From: Bloomer, David <David.Bloomer@lancashire.gov.uk>
Sent: 29 June 2015 08:59
To: Stephen Kilmartin
Cc: LHS Customer Service; planning
Subject: app3/2015/0247 12 Knowsley Road, Wilpshire

Drawing Title
Proposed Unit 3
Floor Plans and Elevations

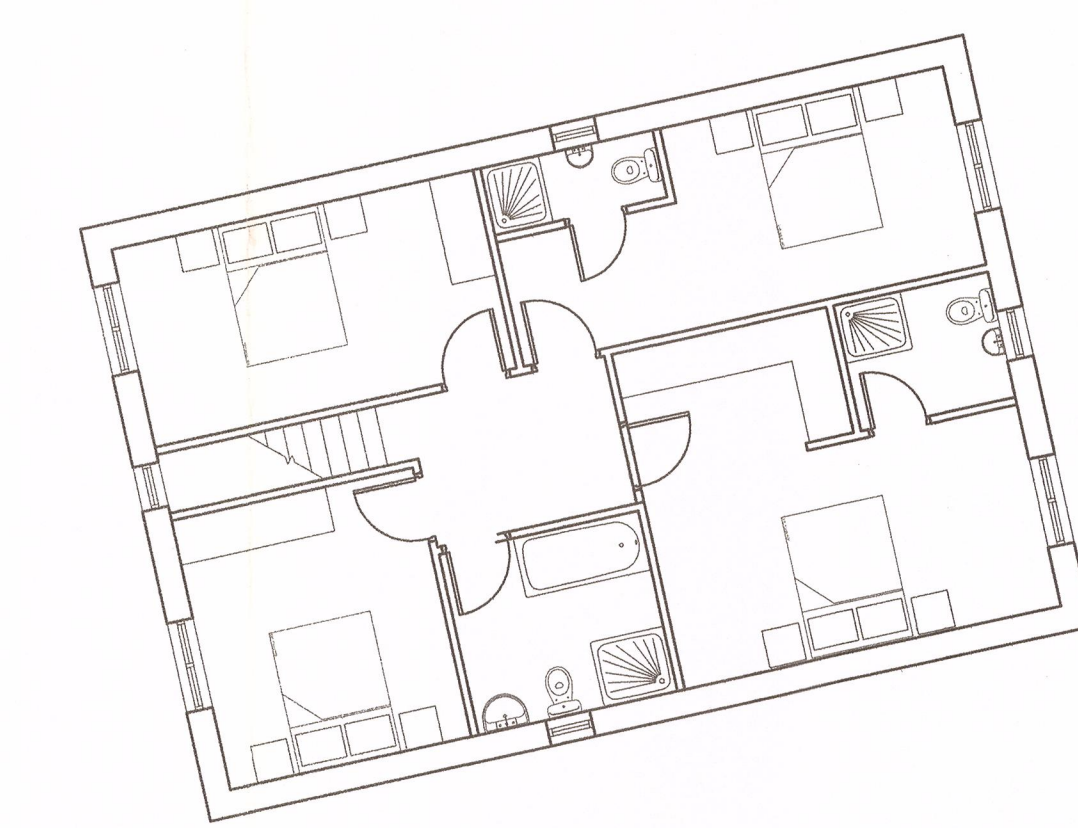
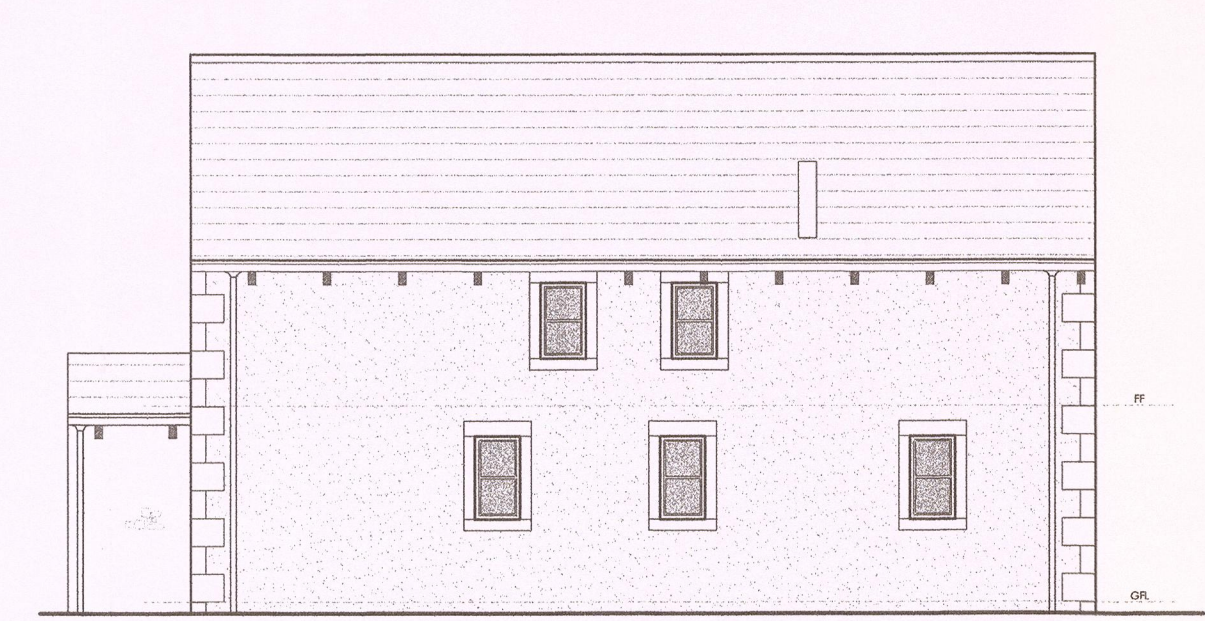
The remaining properties have sufficient parking provision although the garage dimensions for each are below the 6m x 3m standard (allowances can be made for the width as they are double garages but the length is too short).
